**EXHIBITION OF ENVIRONMENTAL ASSESSMENTS FOR COMMERCIAL BUILDING C3
(MP11_0044) AND C5 (MP10_0227) BARANGAROO SOUTH**

General Comments on Commercial Building C3 (MP11_0044)

MP11_0044 (Commercial Building C3) - specific comments

- LLd_A_C3_3080 - TITLE SHEET
- LLd_A_C3_3090 - BASEMENT PLAN LEVEL B1
- LLd_A_C3_3091 - BASEMENT PLAN LEVEL B2
- LLd_A_C3_3092 - BASEMENT PLAN LEVEL B3
- LLd_A_C3_3098 - CROSS SECTION 1-1
- LLd_A_C3_3099 - LONGITUDINAL SECTION 2-2

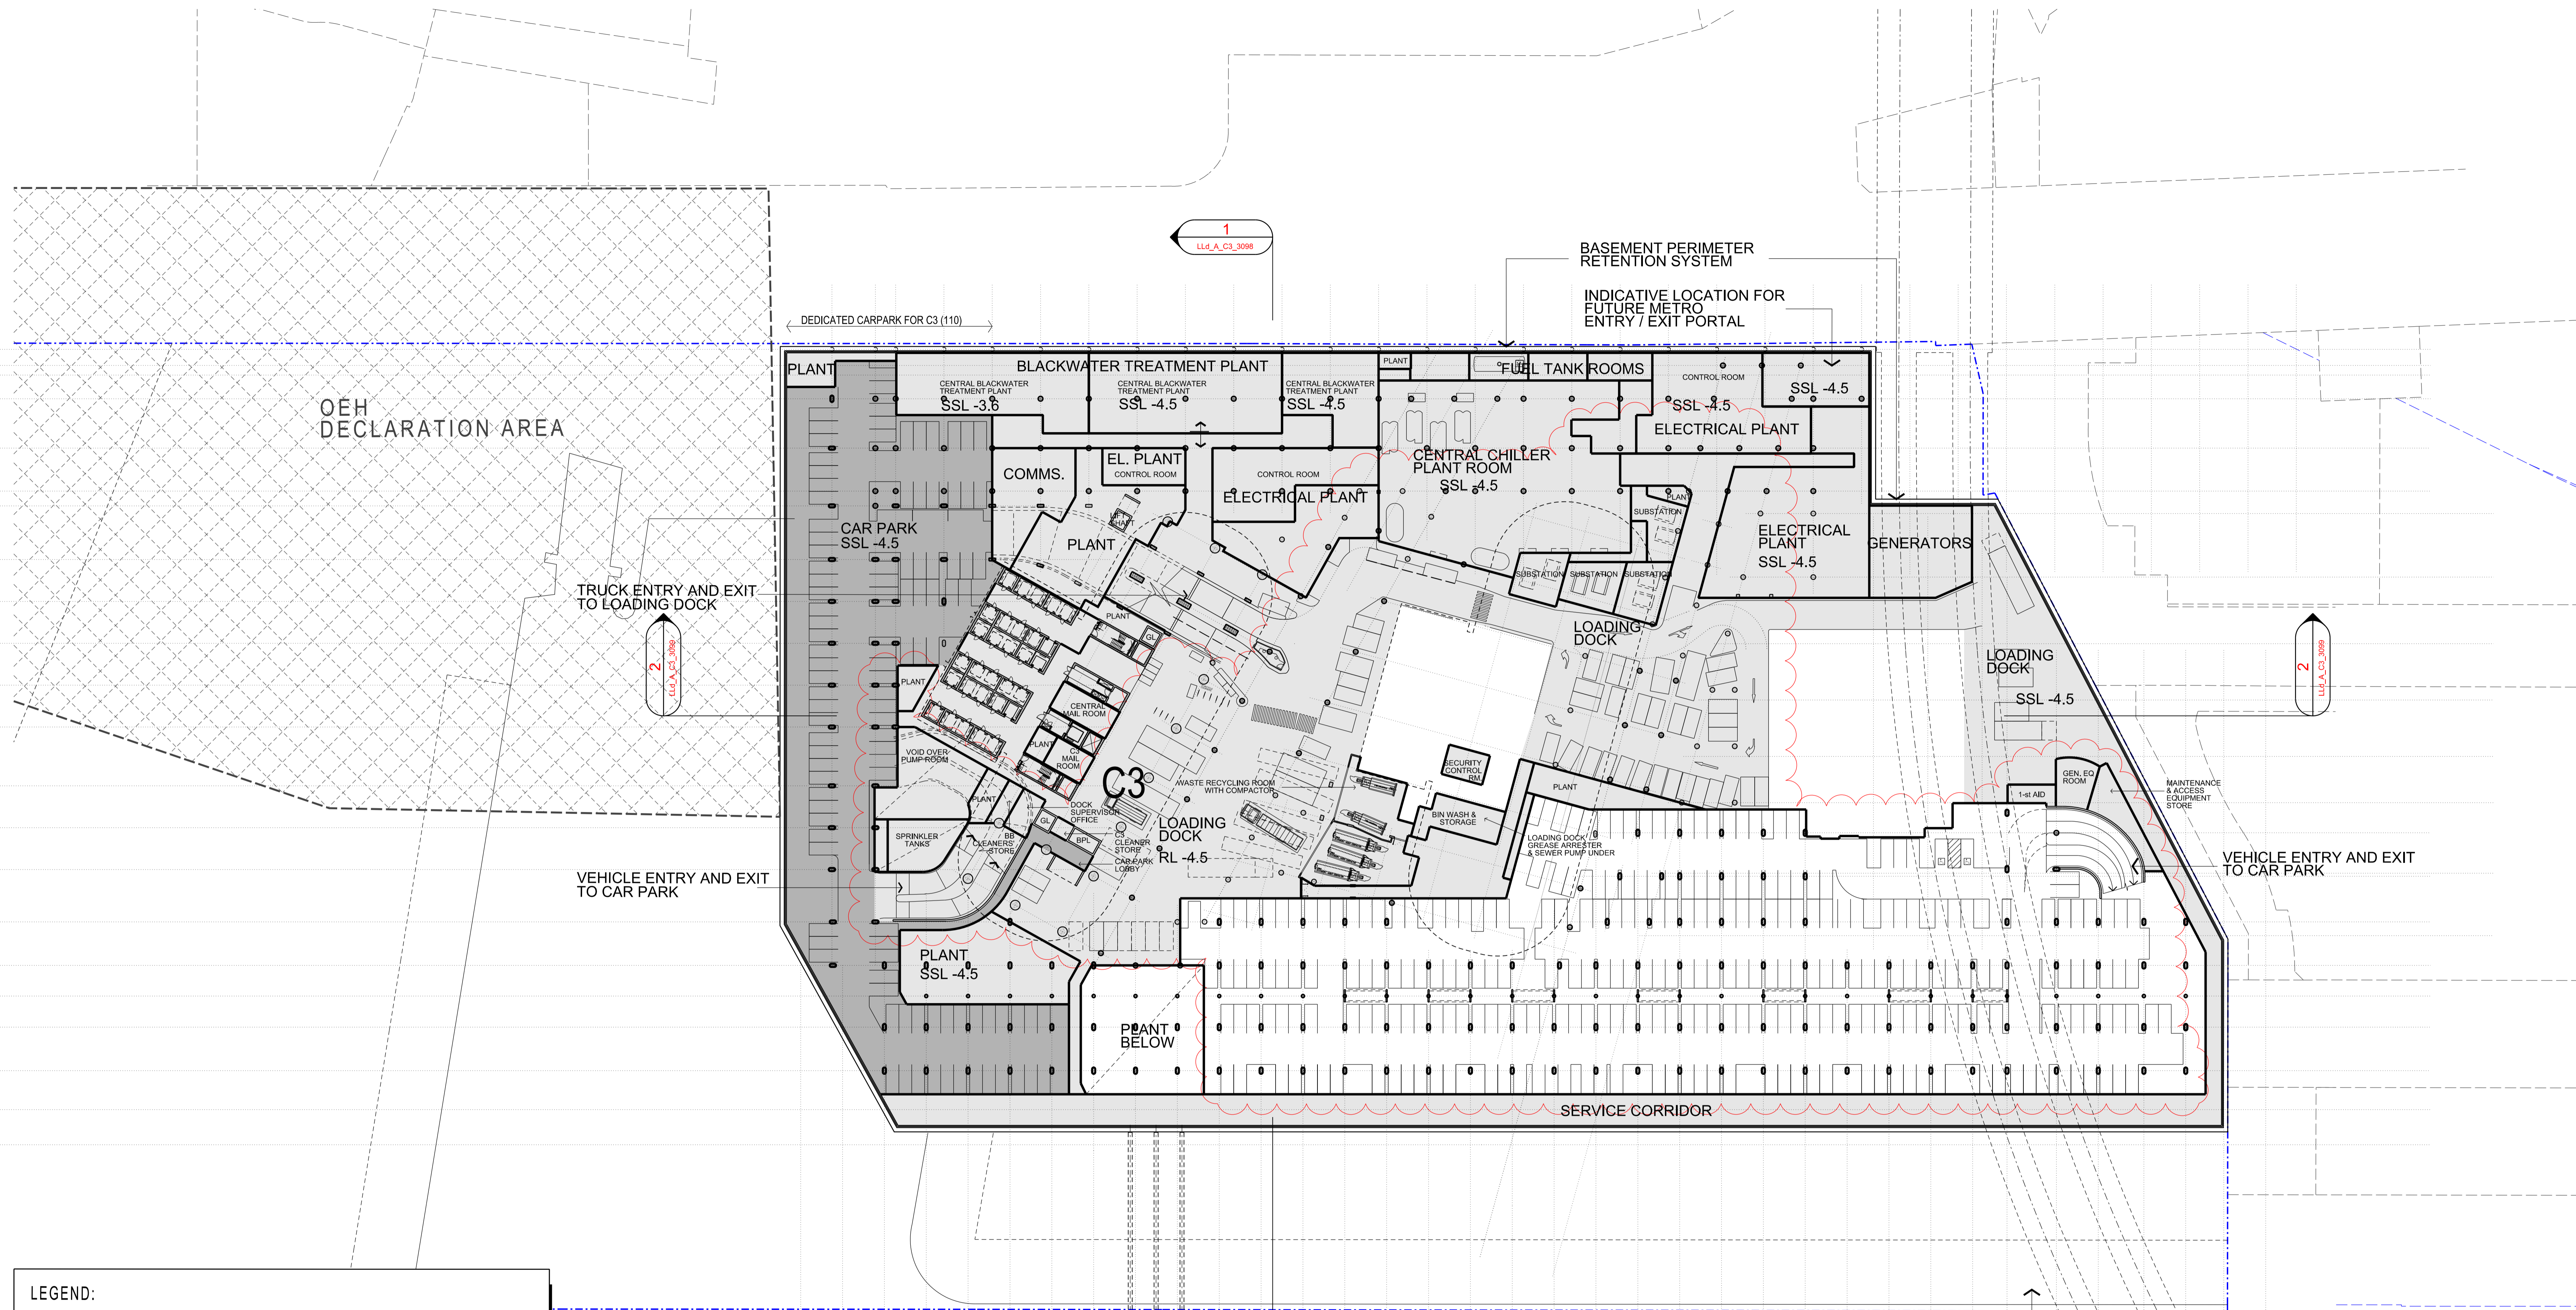
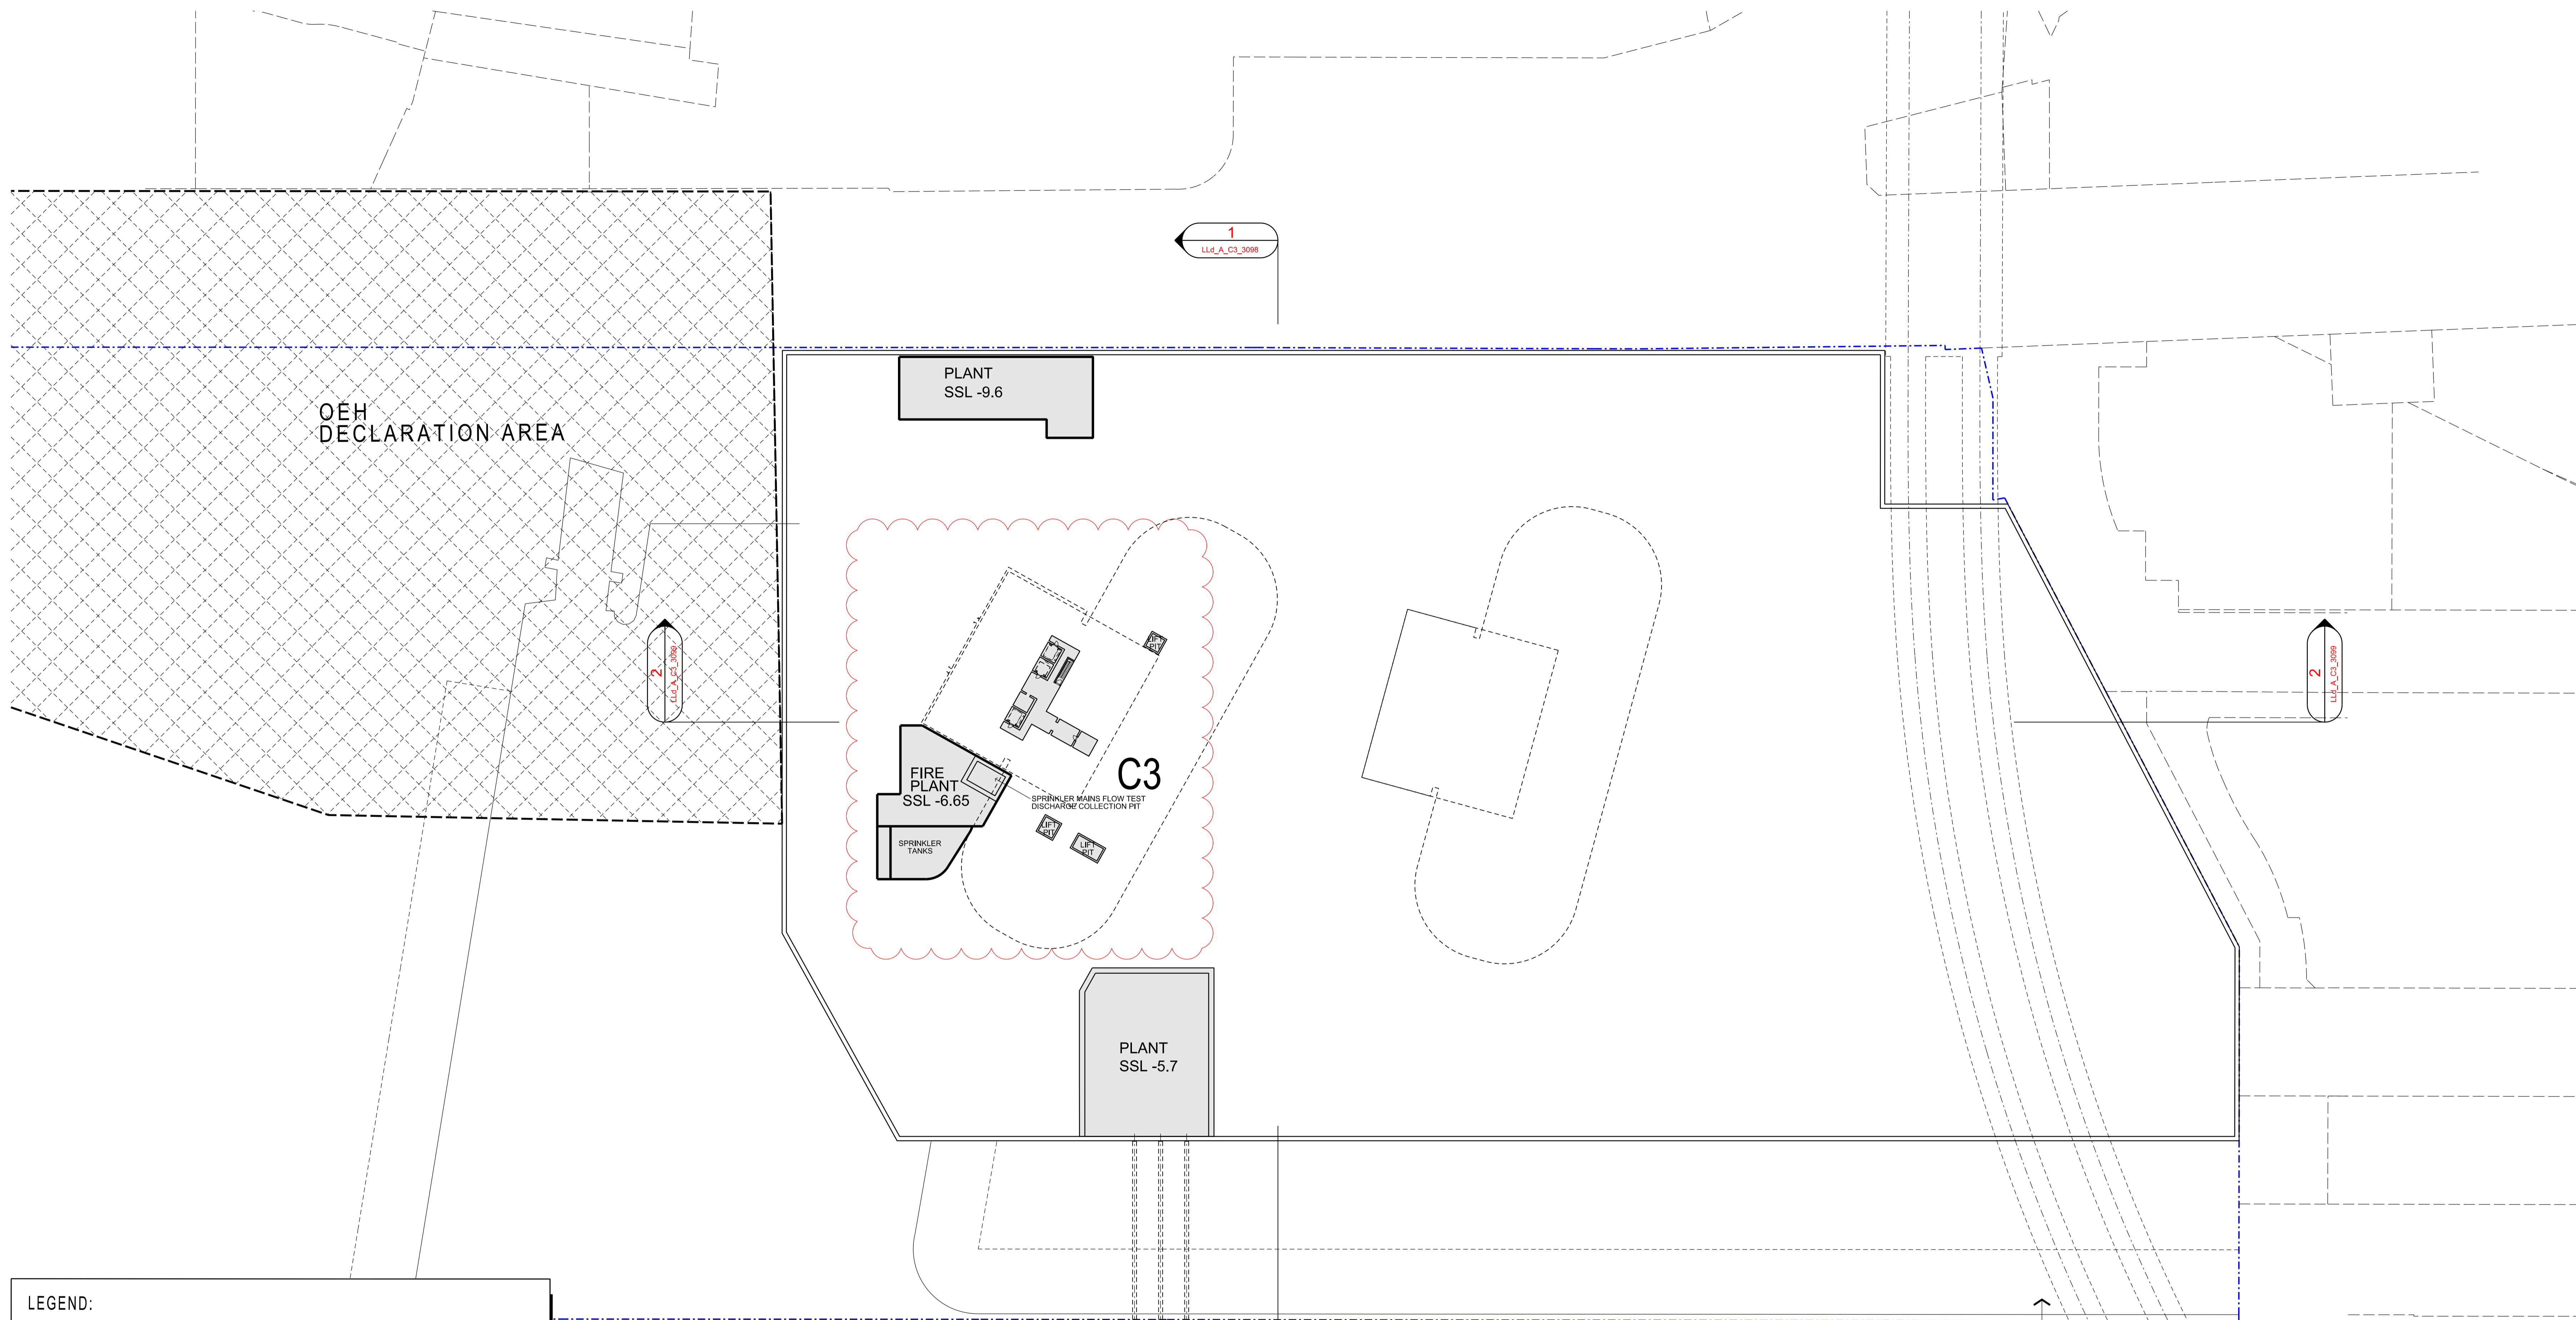
Section 4.10 and Appendix D	There is very little detail on the solution for bicycle parking requirements for the development, and the relationship to adjacent development. It appears that there is a single very small shared facility in the basement. The facilities as proposed appear inadequate for the stated number of bicycle spaces. There is no commensurate provision of facilities for	More details are required on the strategy for bicycle access and facilities. The proponent should address the long term bicycle parking requirements.

cyclists within the building floor plates, or explanation and scoping of facility requirements. There are no details on bicycle access from the adjoining street networks. The maps provided in the supplementary TMAP are general in nature.	Appendix A: Plans	Allocation of staff change facilities within the building's basement appear to be inadequate. Based on the drawings provided, and comparing C3, C4 and C5 indicative basement layouts. A single common staff change facility is provided under C4. This is considered inadequate if this is to service the stated 1,000 plus spaces allocated for bicycle storage. The locality is not convenient to personnel accessing buildings C3 or C5. Note: The building floor plans do not appear to contain any shower facilities in any of the tenancy floors.	Section 5.27 T Appendix The Construction TMP should include consideration of Wynyard Walk, particularly in relation to the reduced road capacity on Napoleon and Margaret Streets. The cumulative impacts of Wynyard Walk have not been identified or considered. The statement that there are no other major construction projects within the vicinity of Barangaroo known at this point in time is incorrect.	Appendix T The Construction Transport Management Plan needs to be amended to reflect comments and updates submitted to Lend Lease on the s75V modifications for Commercial Building C4 and the Basement Excavation and Car parking. Key issues raised include: • Update figures showing vehicle access to site • Resolution of Napoleon Street intersection with RMS.	Appendix T Developer to ensure that issues are addressed in the CTMP to be approved prior to issue of construction certificate Developer to consult with Transport for NSW regarding the CTMP prior to issue of construction certificate Developer to ensure that issues are addressed in the CTMP to be approved prior to issue of construction certificate Developer to consult with Transport for NSW regarding the CTMP prior to issue of construction certificate Developer to ensure that issues are addressed in the CTMP to be approved prior to issue of construction certificate Developer to ensure that issues are addressed in the CTMP to be approved prior to issue of construction certificate
